18th December 2015

State Significant Development Application and Variation of the Sydney Cove Redevelopment Scheme for the “Remediation, Renewal and Adaptive Re-Use of Campbell's Stores”, The Rocks (SSD 7056)

03 NORTH ELEVATION  
SCALE 1:200

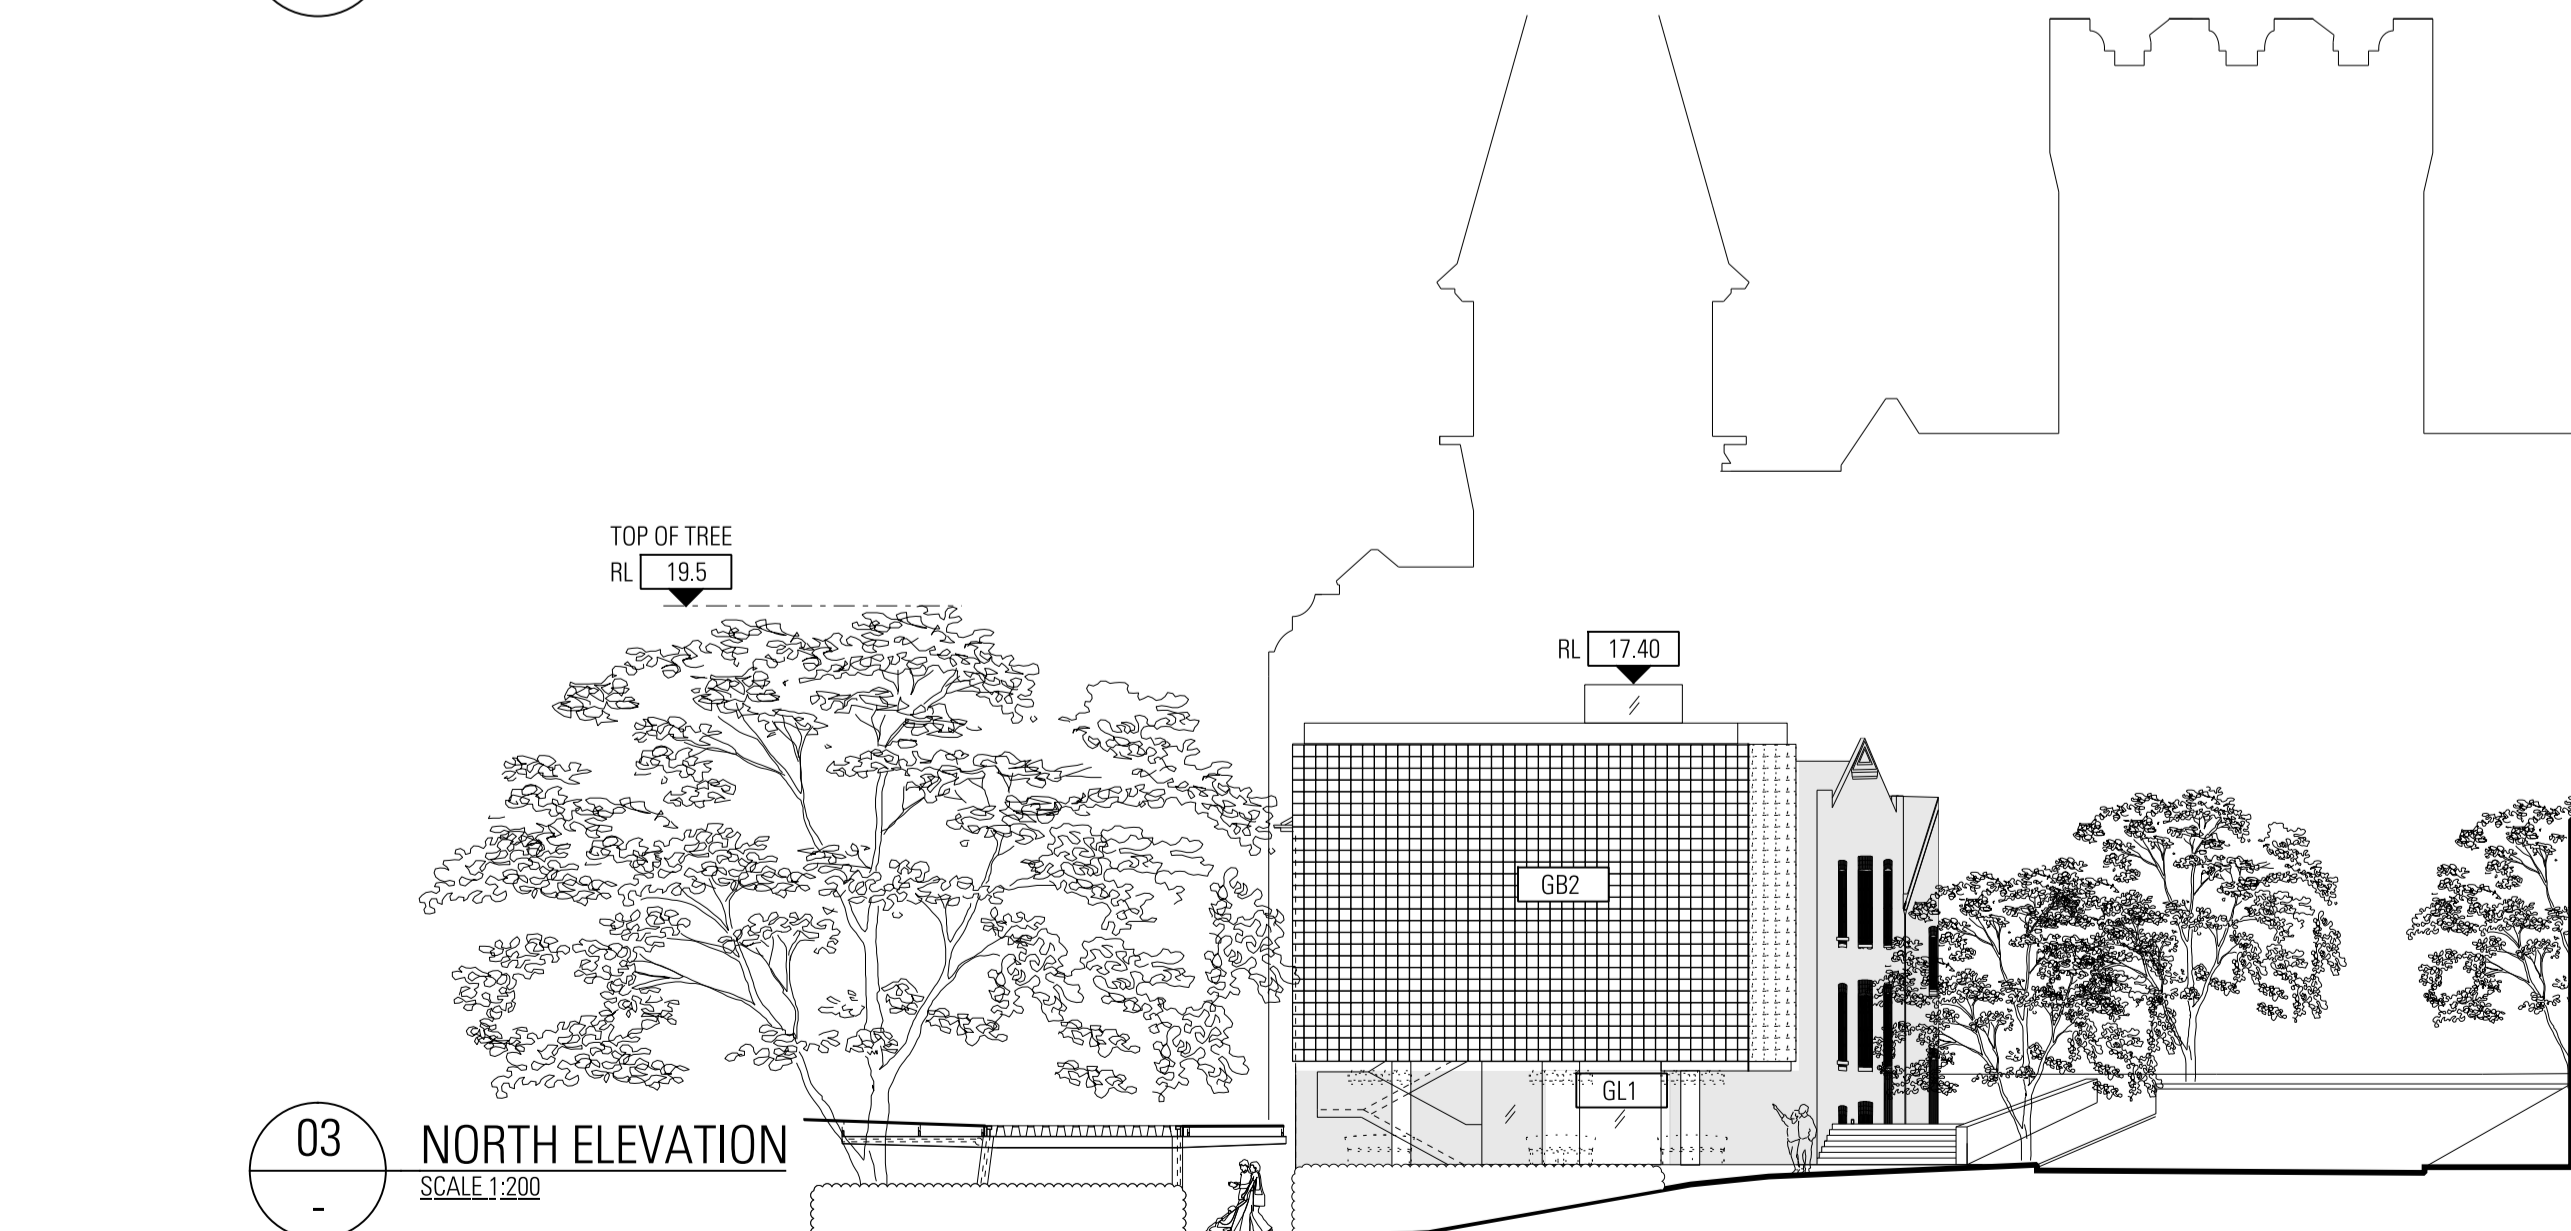
- The proposed new ground level would be 1.94 metres higher than the existing one so as to accommodate a basement area. Contrary to claims that there would be a four metre setback between the two buildings, the basement level of the glass box would abut the Stores and effectively bury the ground floor of the Stores' 'Highly Significant' northern façade almost to the tops of its existing windows. This is shown very clearly in the following sections of JPW's Design Statement – the northern elevation profile (p.96,) the Concepts diagram (p.102) and the Bay 12 'artistic impression' (artistic

- The glass box would destroy the opportunity for people to appreciate Campbell's Stores' significance as a stand-alone industrial building within its maritime setting. It would obscure views of the northern elevation of Bay 11. This would be particularly the case for people trying to view the Stores from the northern end of Hickson Road, from the pedestrian pathway on the eastern side of the Sydney Harbour Bridge and from Dawes Point Park. (see Appendix C2 Photomontages 6a and 7a). Its raised ground level would 'bury' most of the ground floor of the Campbell's Stores northern elevation.

Building Massing

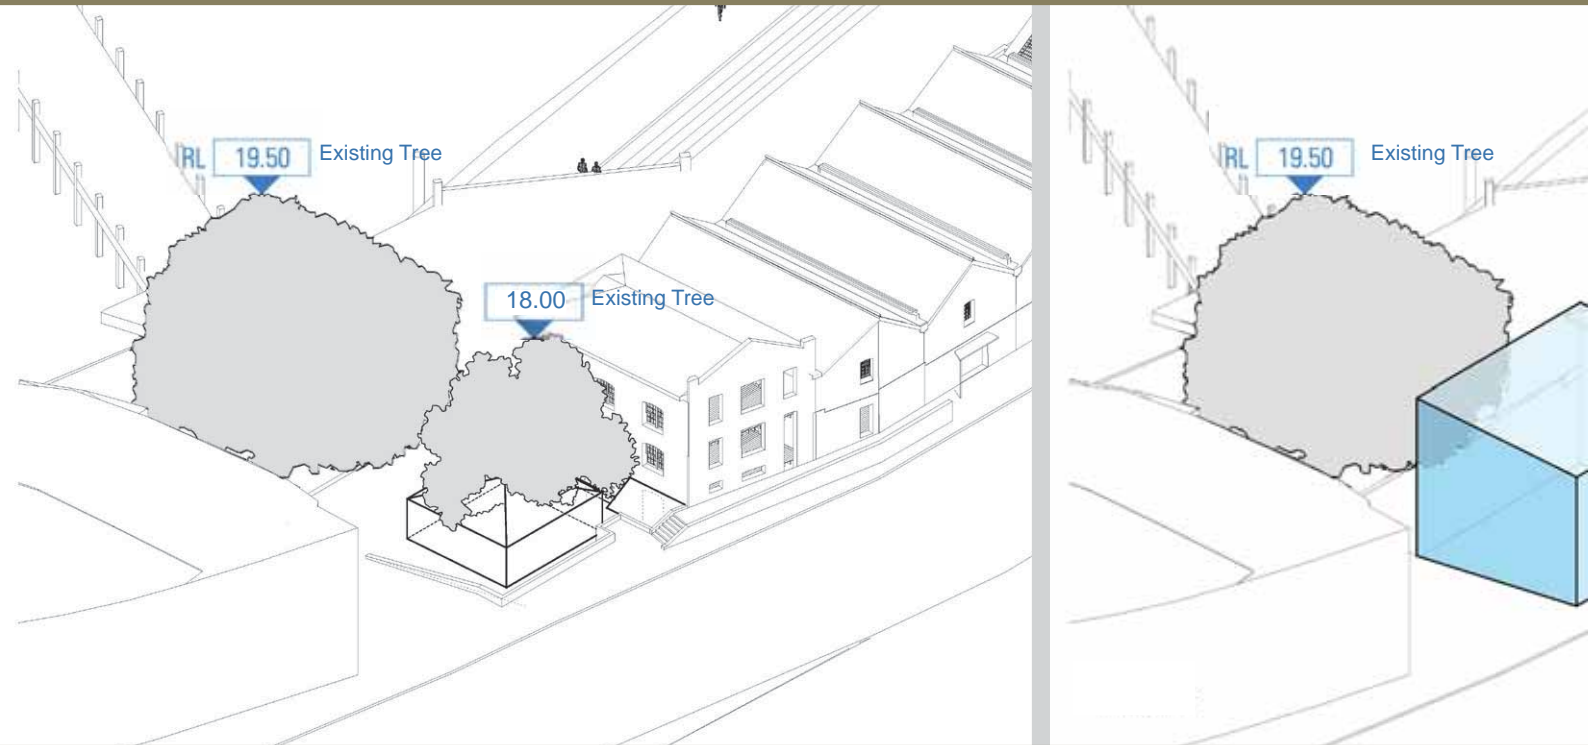
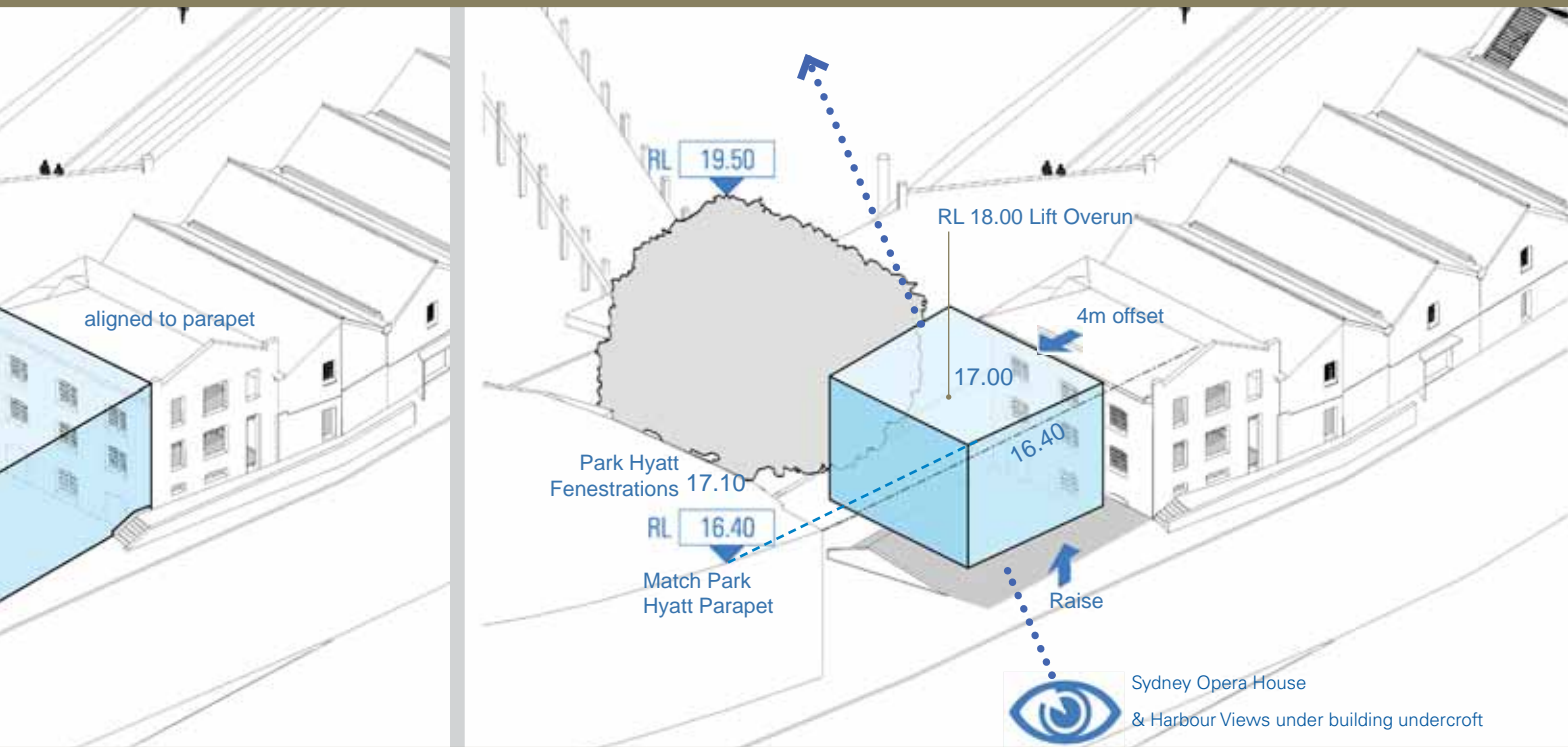
- The glass building would comprise three levels sitting on four columns. It would have the appearance of a tall and bulky glass box on stilts and would obscure all of the Stores' northern elevation. Its minimal 2.5 metre undercroft would be oppressive and tunnel-like and this, along with its intended used for outdoor eating, would serve as a barrier, limiting public access to the foreshore and severely constraining existing views to the Opera House from this location.

- The proposed glass box would be located next to Bay 11 on the northern elevation of Campbell's Stores. When measured from the proposed new ground level, it would be 13.3 metres high with the inclusion of its 1 metre high lift overrun. This exceeds the height restriction on the foreshore frontage by 14.5m, more than 250% and on the Hickson Road elevation by 10.5m, or 140%. **This would require a significant spot re-zoning under the Sydney Cove Re-Development Authority Scheme (SCRAS). One-off variations to this should not be permitted in advance of the Premier's holistic review of planning for the Sydney harbour foreshore.**

- Given this height and bulk, the proposed new four-storey glass box would dwarf the heritage-listed Stores, dominate the Campbell's Cove foreshore and be the tallest building on this section of the Hickson Rd streetscape.

HICKSON ROAD ELEVATION (NTS)

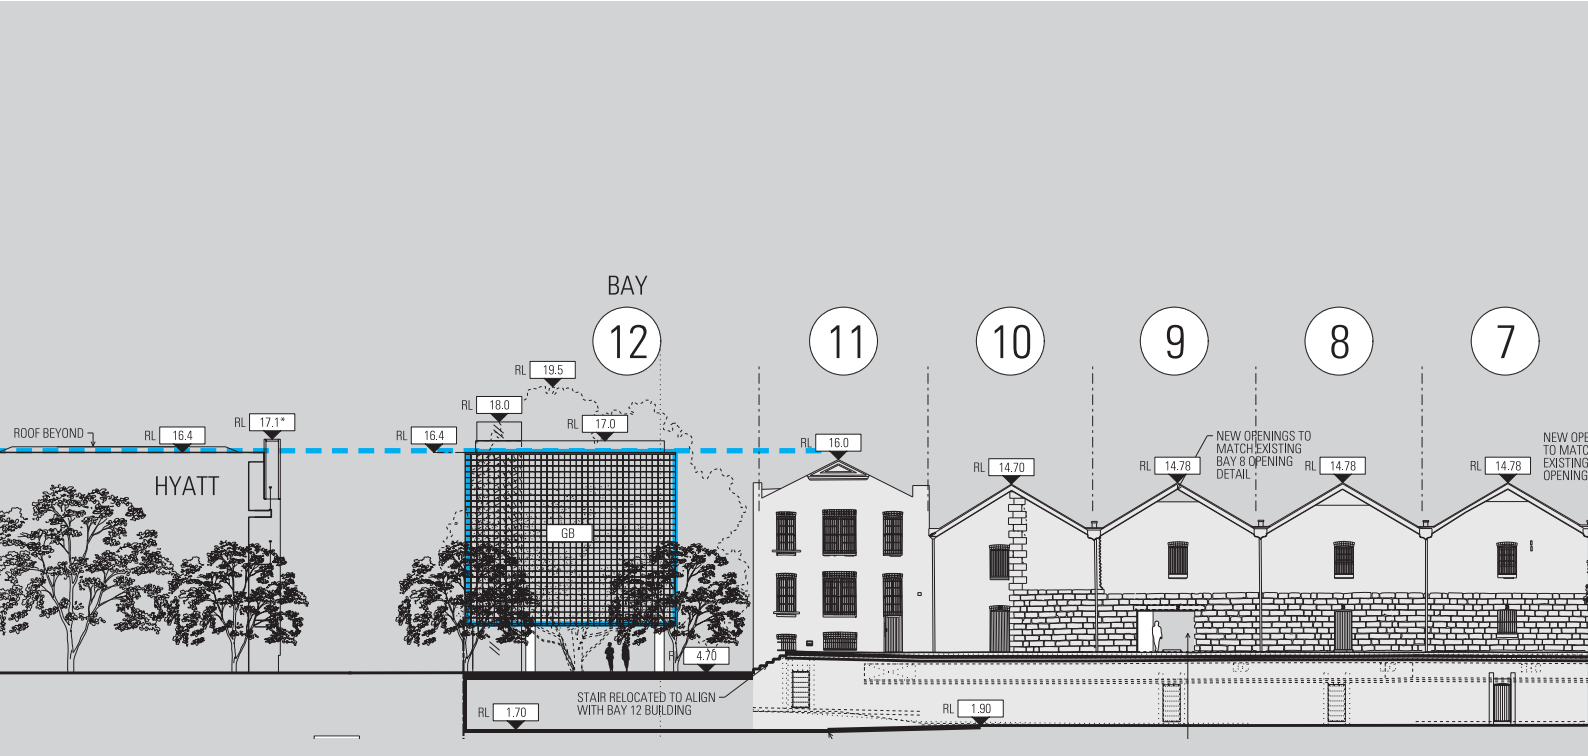
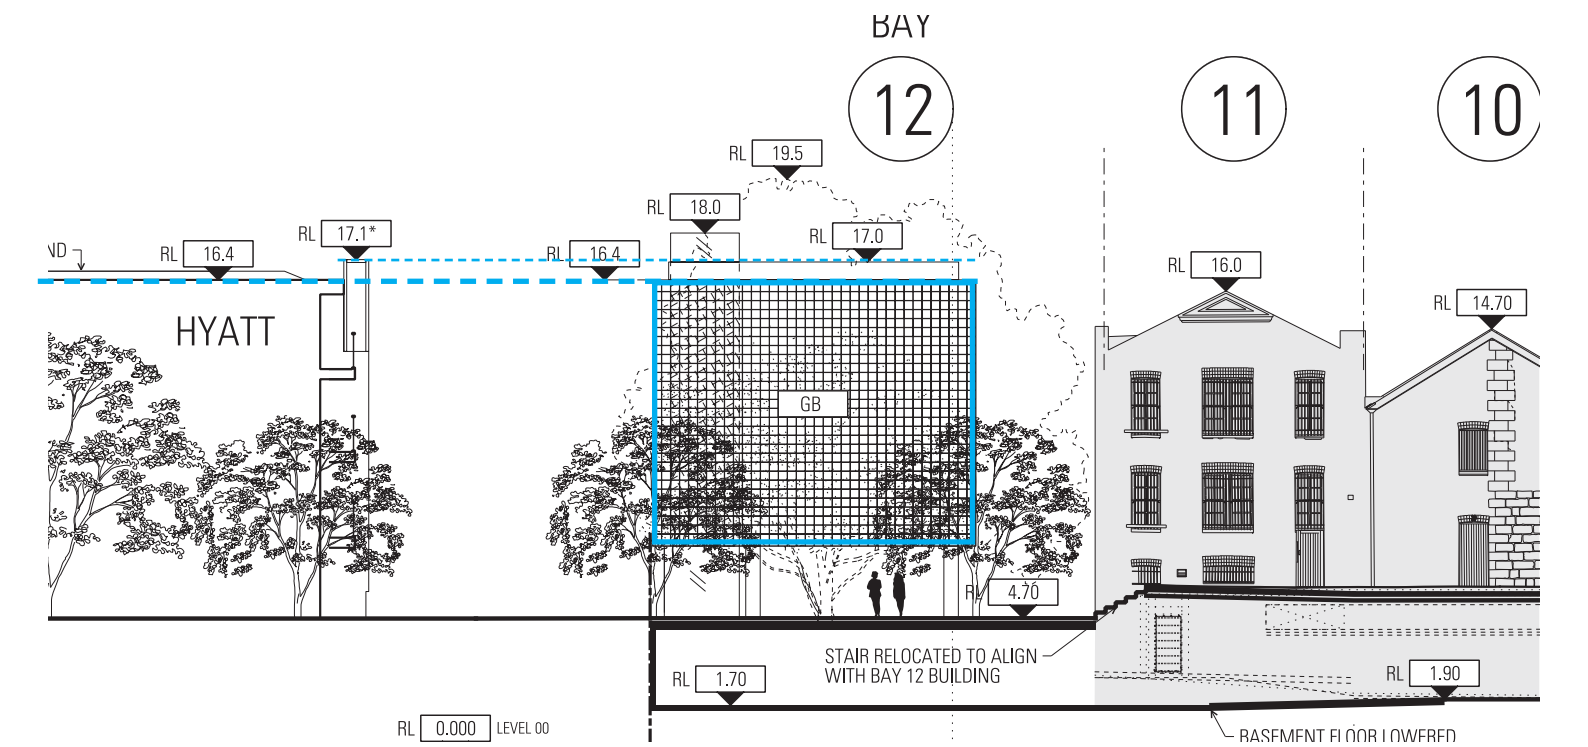
Another typical example of the apparent deception is the diagram on page 96 of the Design Statement shows that the glass box would be one full storey higher than the gutter level of Campbell's Stores and then there'd be the lift overrun on top of that! There's a lot of detail and information conveniently included in those diagrams that is not evident elsewhere.
